LIBERTY TREE ACADEMY CONSTRUCTION DOCUMENTS

TOWN OF PEYTON, EL PASO COUNTY

PRELIMINARY DESIGN

LIBERTY TREE ACADEMY			
TOWN OF PEYTON, EL PASO COUNTY CONSTRUCTION DOCUMENTS			
TITLE SHEET			
DESIGNED BY:	ACR	SCALE:	DATE ISSUED:
DRAWN BY:	ACR	HORIZ.	MAY 2018
CHECKED BY:	DRK	VERT.	SHEET 1 OF 19
FOR AND ON BEHALF OF MATRIX DESIGN GROUP, INC. PROJECT No. 18.995.001			DRAWING No. TS01

DESIGNED BY: ACR	SCALE: HORIZ.	DATE ISSUED: JUNE 2018	DRAWING No. GR01
DRAWN BY: ACR	SCALE: VERT.	SHEET: 3 OF 11	
CHECKED BY: DRK

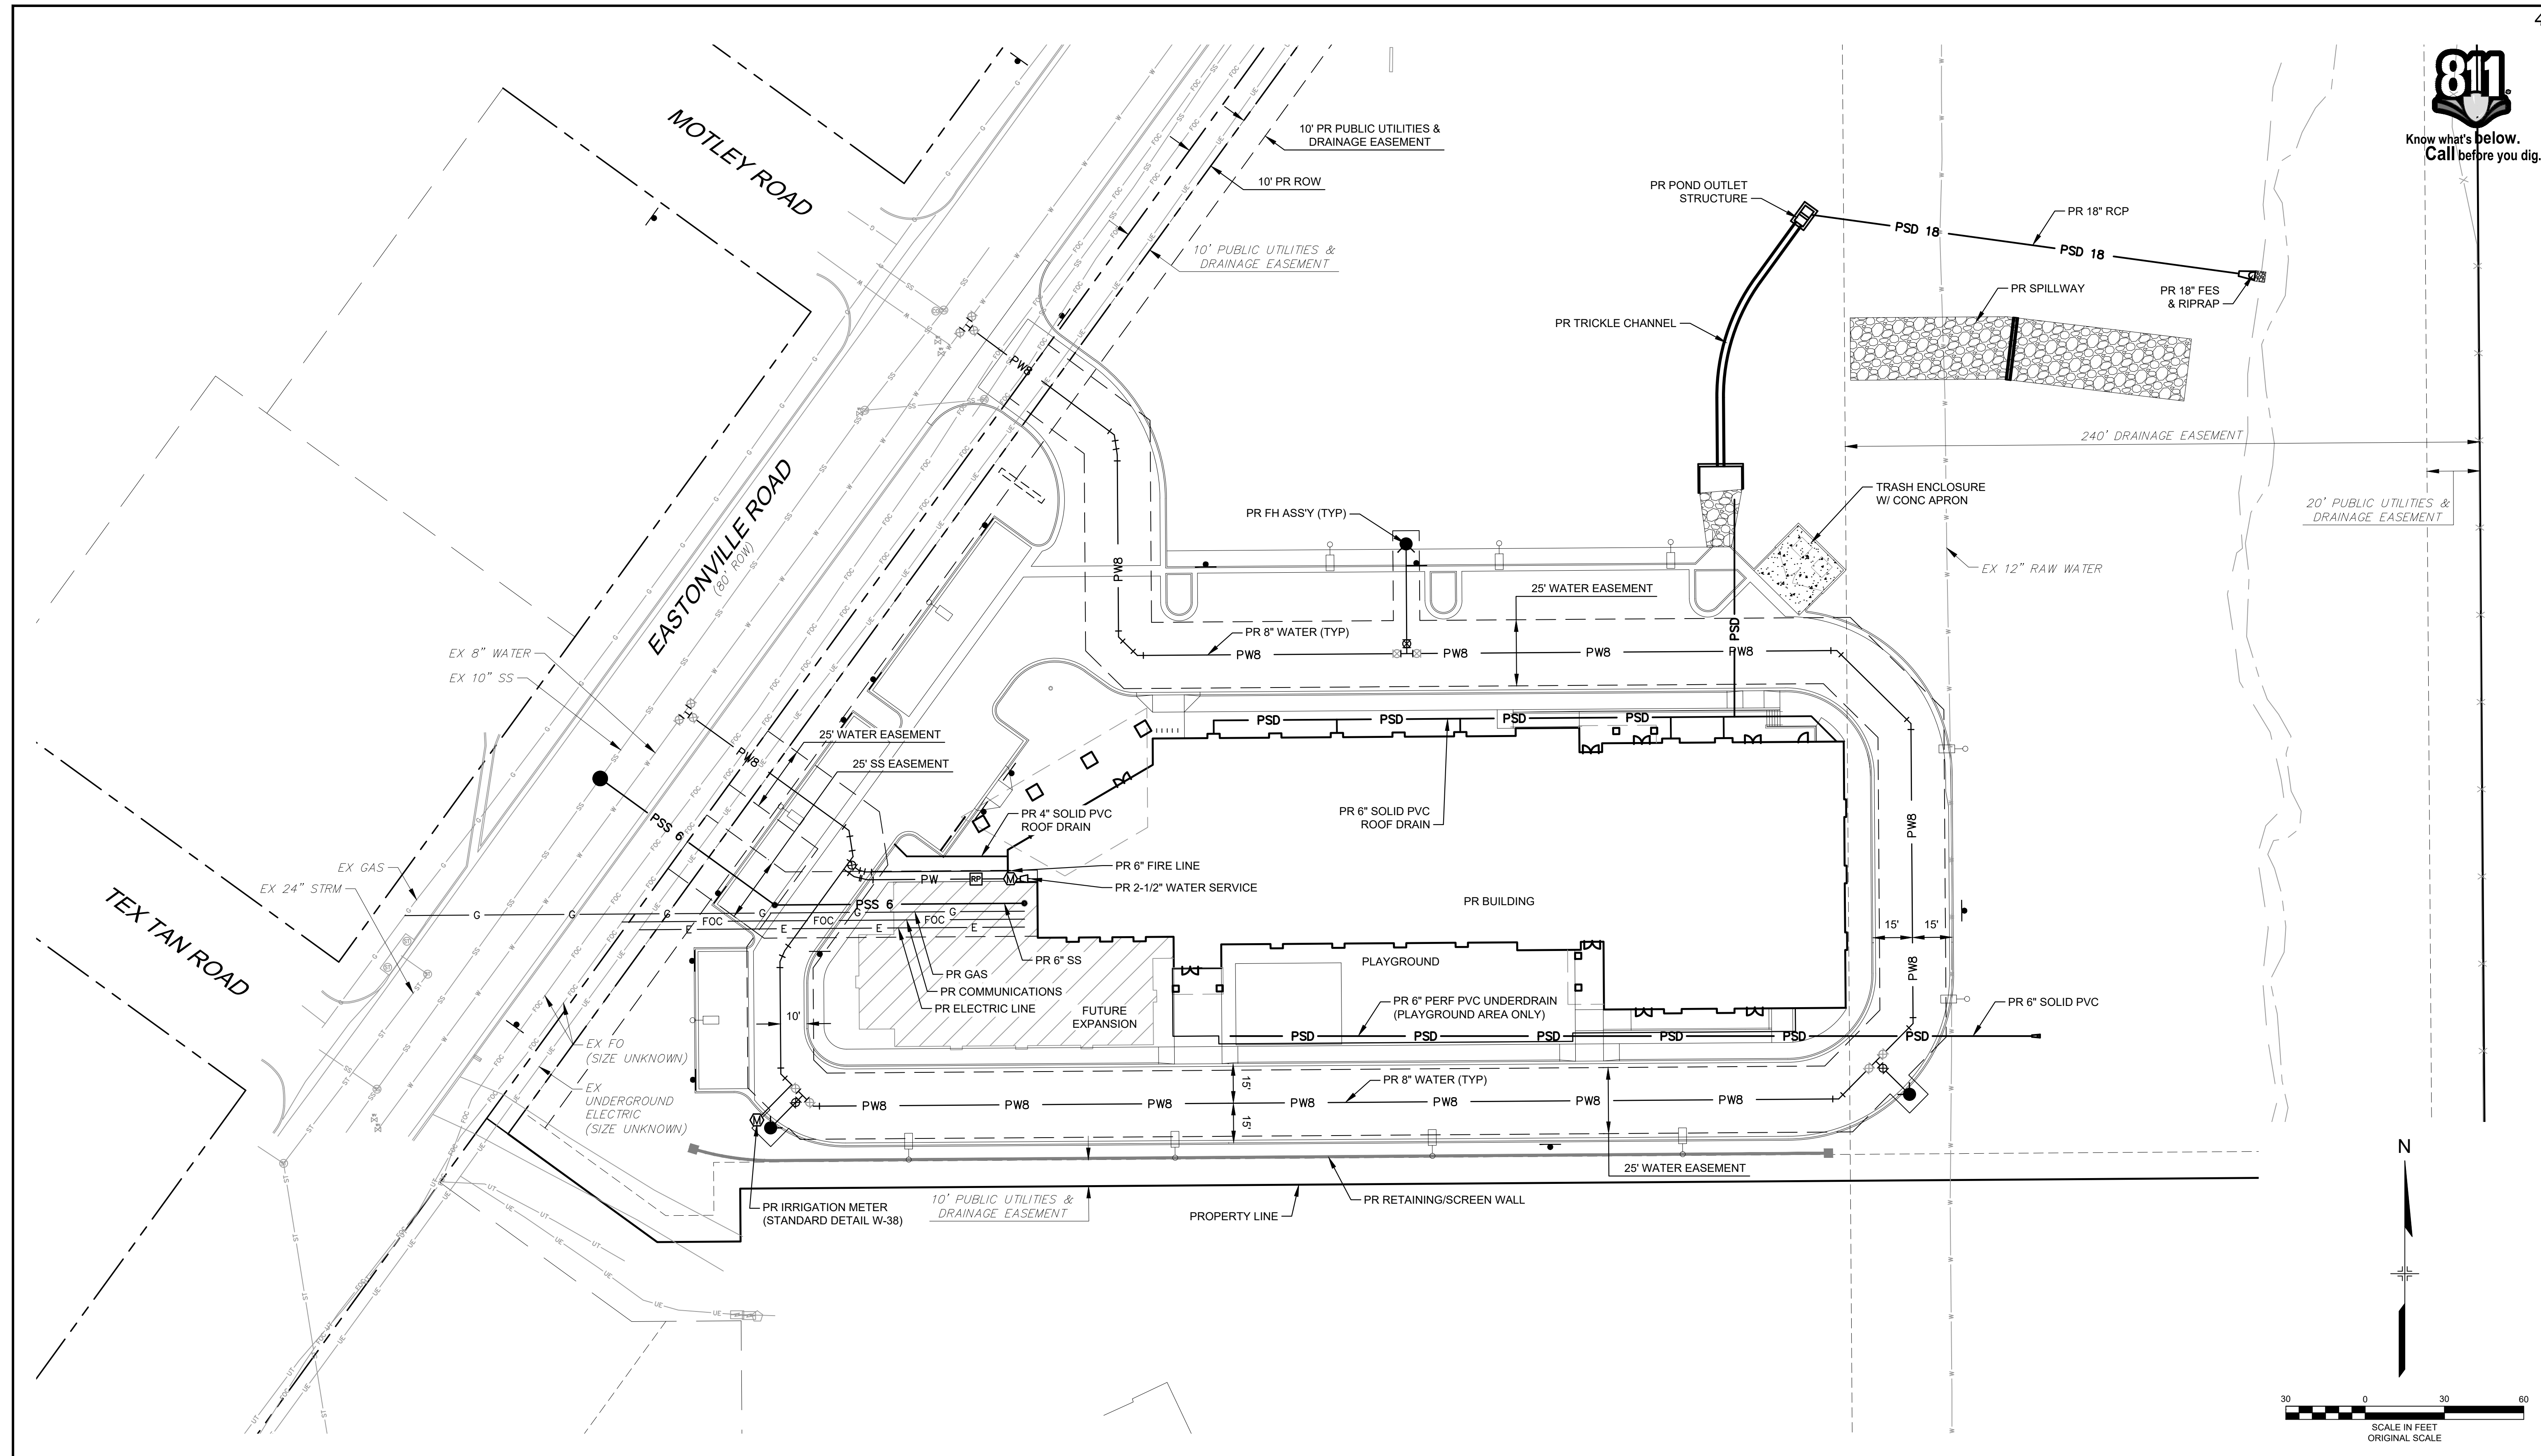
Show and label access trail (all applicable sheets).

Show channel cross-section locations and approximate 100-year water surface and depth (all applicable plans).

Clearly show and label existing driveway (all applicable plans). Provide documentation of correspondence with the other property owner.
